CITY OF ALBUQUERQUE

RE: **Casitas de Colores** – Grading & Drainage Plan for Work Order & Building Permit
215 Lead Ave. S.W. P.E. Stamp: 09/04/12 (**K14-D087A**)

Based upon the information provided in your submittal received 9-6-2012, the above referenced plan cannot be approved for Work Order or Building Permit until the following comments are addressed:

**GRADING &  
DRAINAGE PLAN**

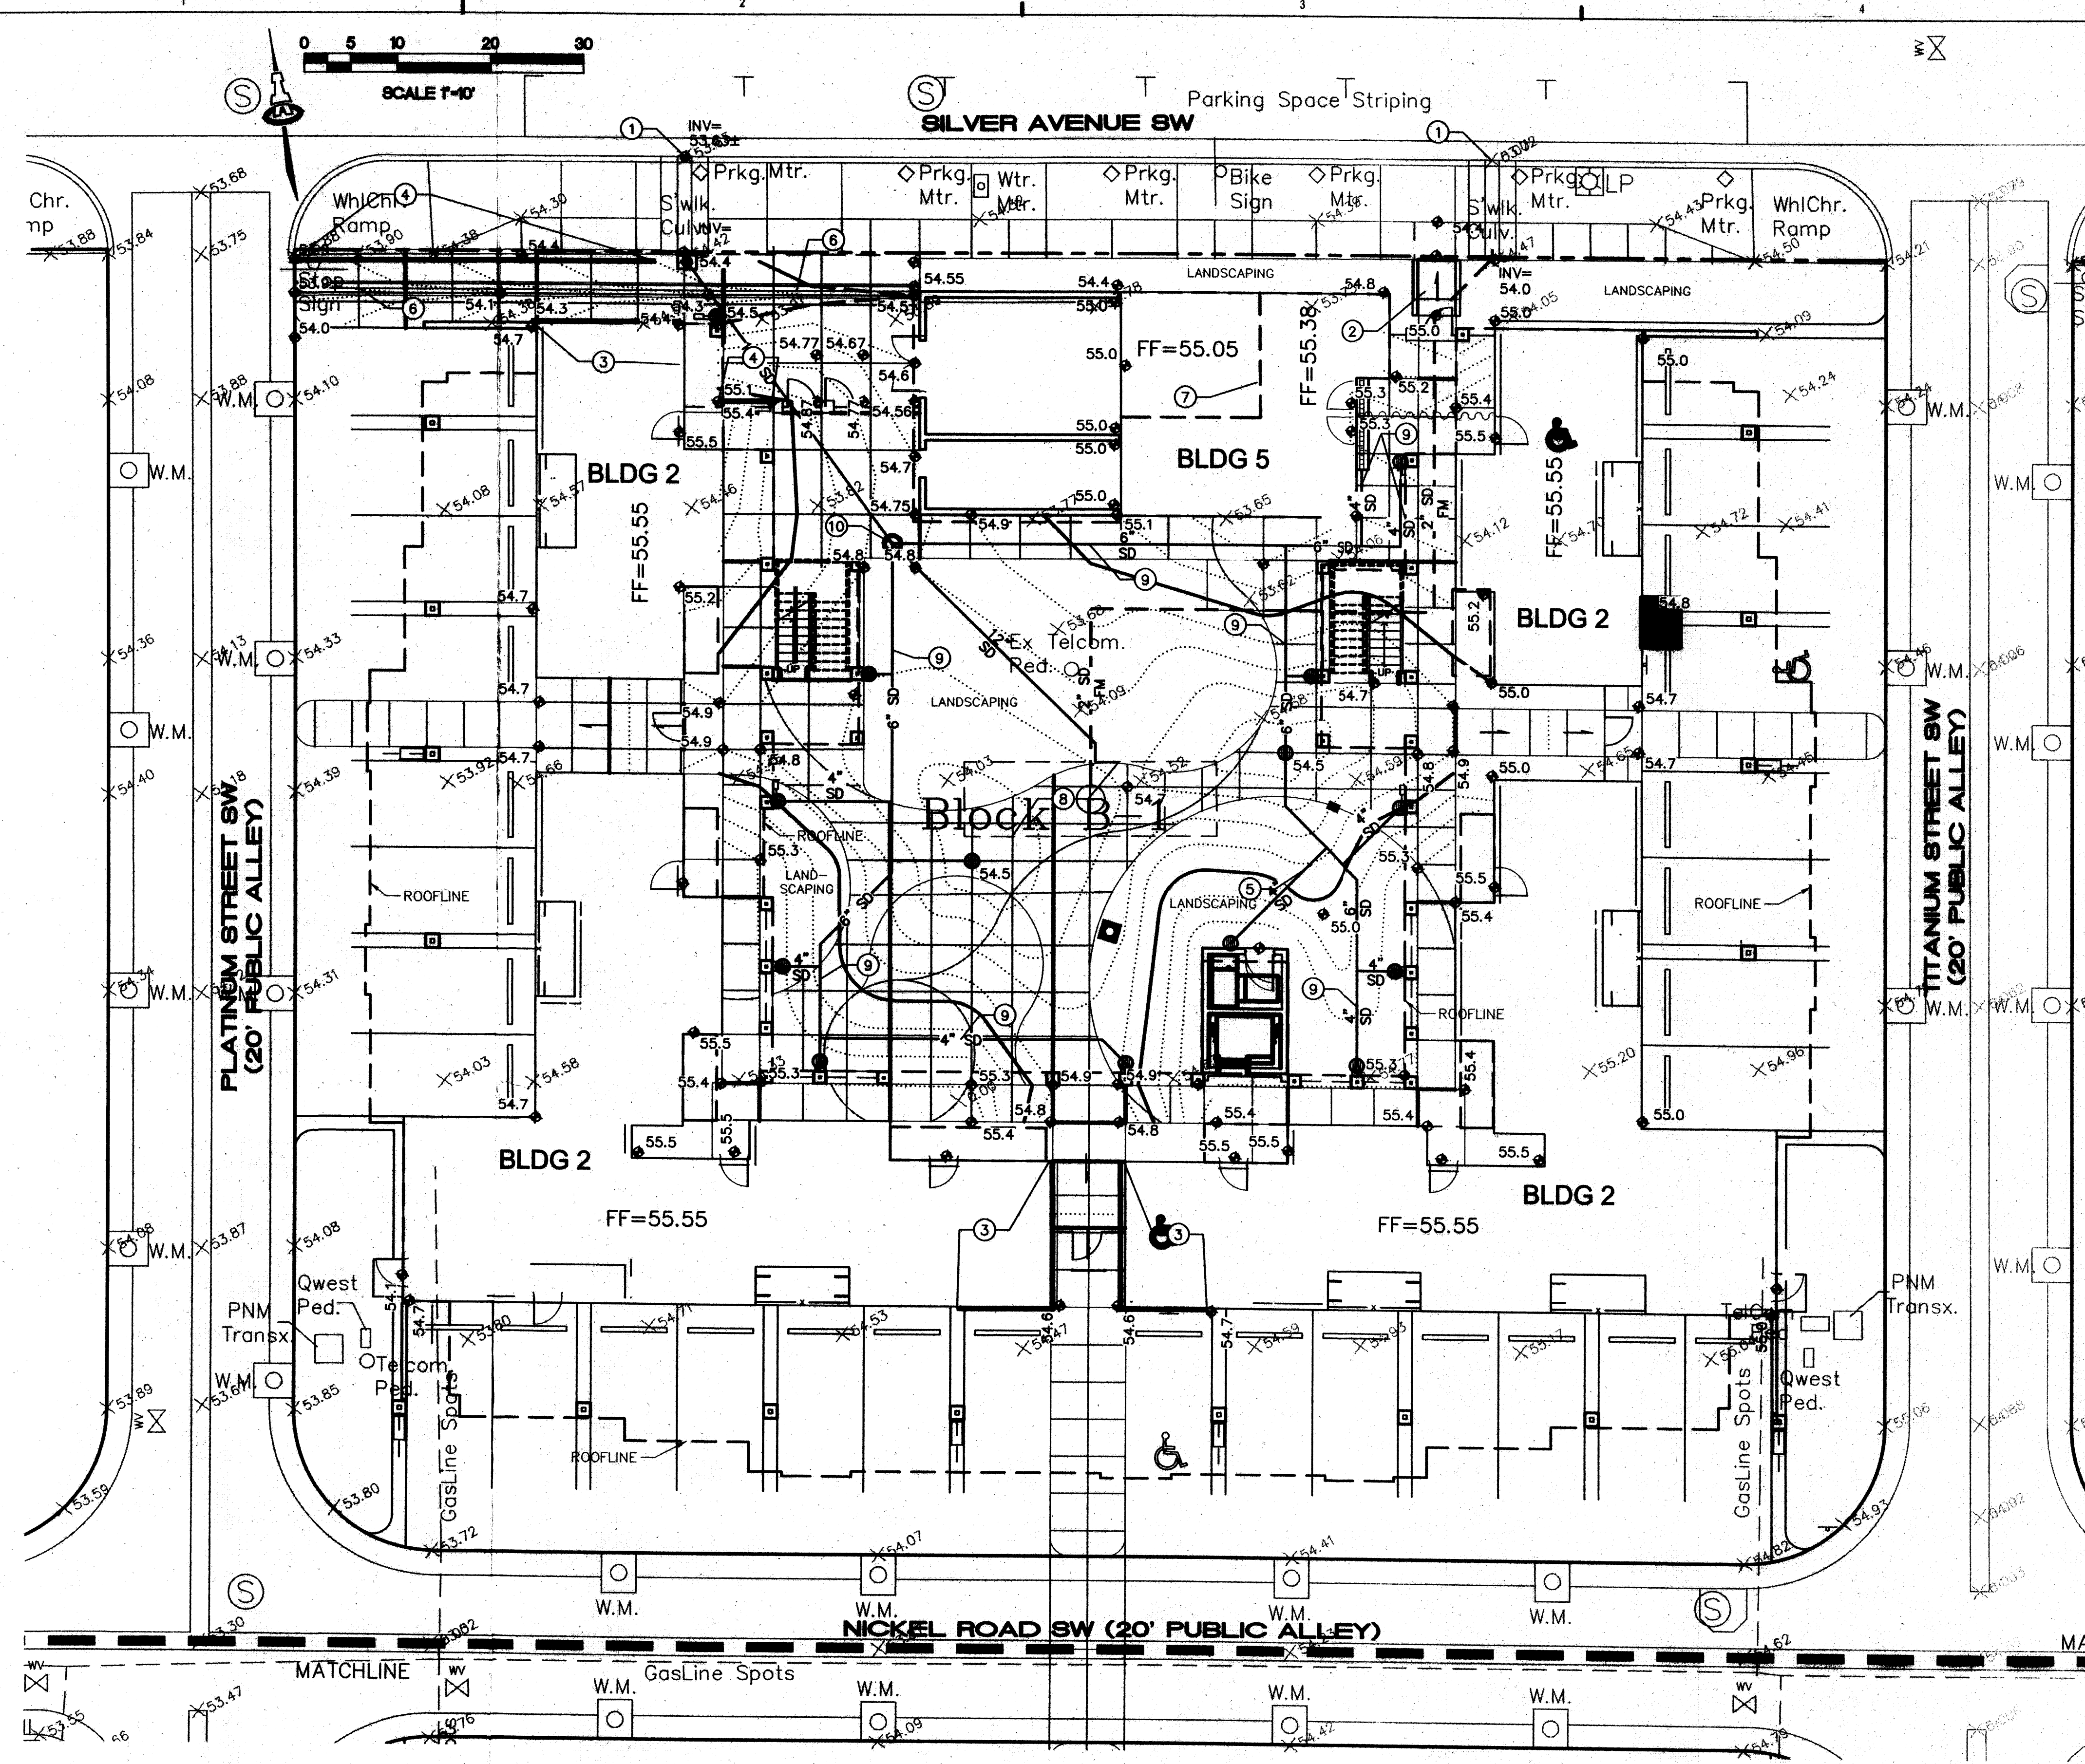
2. **CG-101 & 102:** Show on the G&D plans where roof drainage from each building discharges and flows. *(Alternatively, this may be adequately shown on the basin map.)*

3. **CG-101:** Could the roof drain pipe (Key note 11) be tied to the Cistern overflow line, instead of surface discharging to the alley gutter? (possible icing problem on SW)

4. **CG-101:** Provide more detail of how the 2" PVC Force Main will connect to the existing SW Culvert on Silver Ave. Provide a safe, edge of sidewalk condition, by extending the SW culvert back of sidewalk, or other means to avoid drop-off at back edge of SW.

GRADING &  
DRAINAGE PLAN

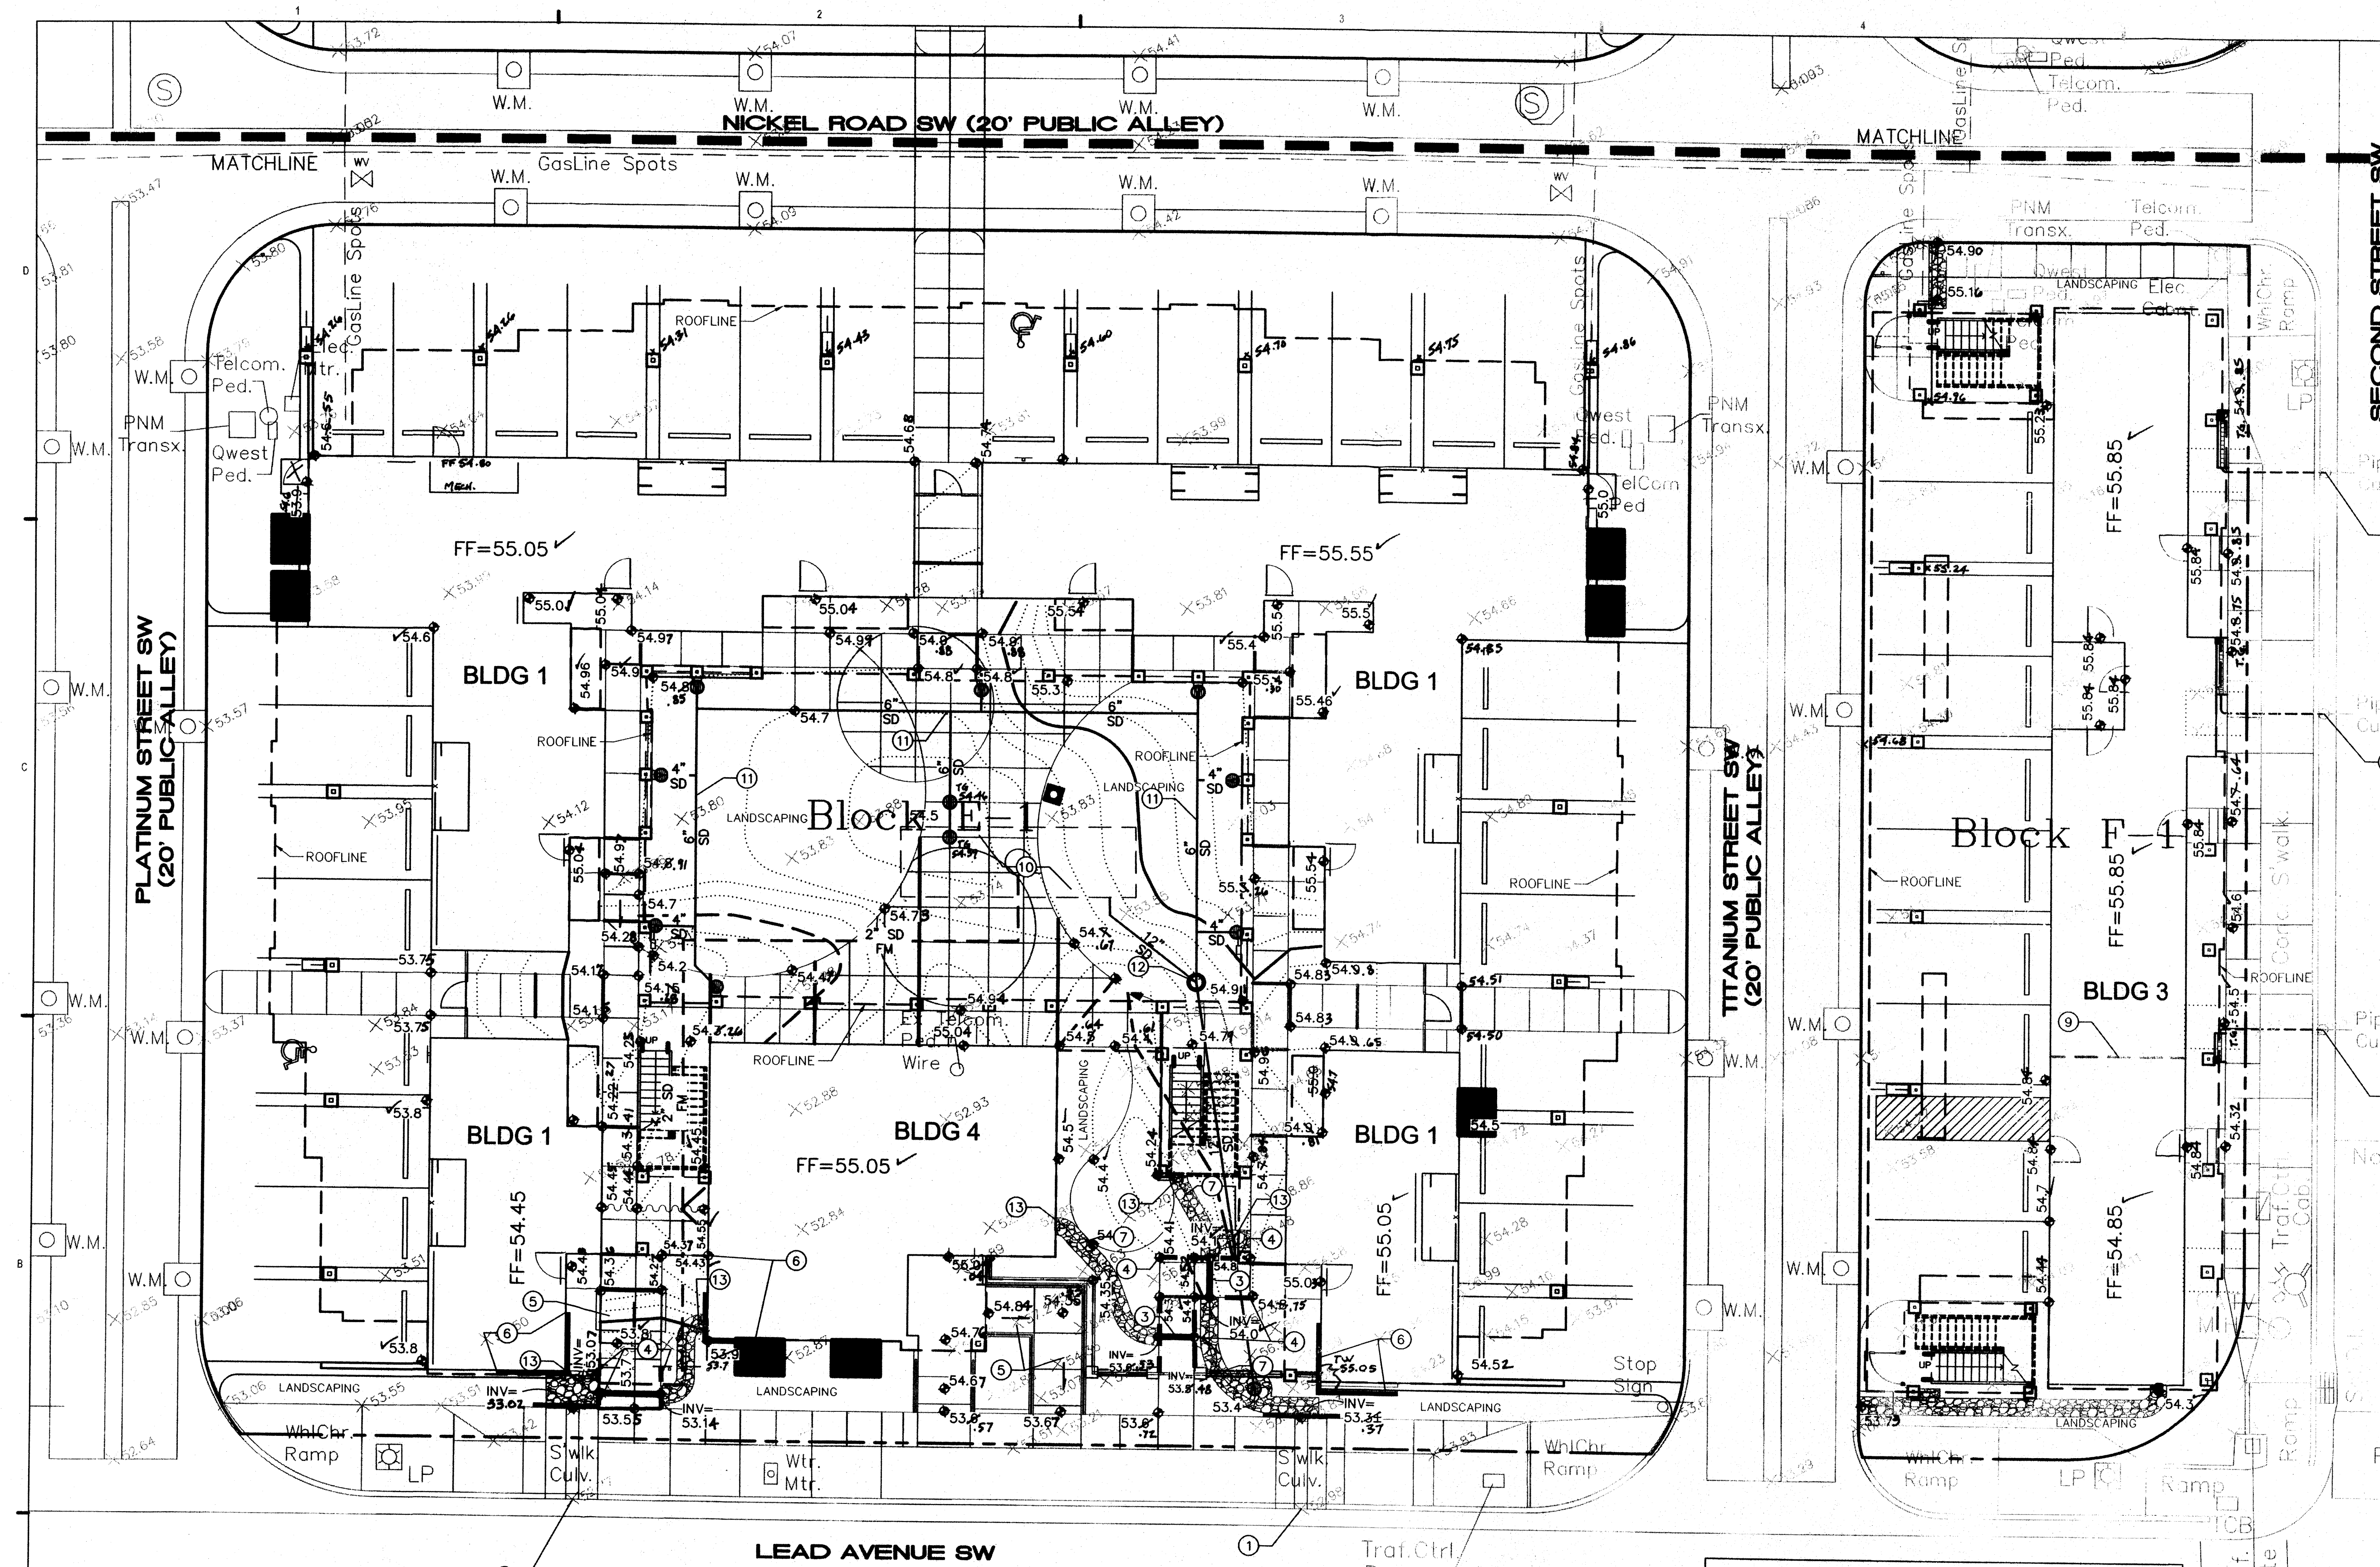
5. **CG-102:** Provide detail of how the Rock Swales enter the existing SW culverts. Provide a safe, edge of sidewalk condition, by extending the SW culvert back of sidewalk, or other means to avoid drop-off at back edge of SW. Also address how the 2" PVC Force Main will enter the western SW Culvert on Lead Ave.
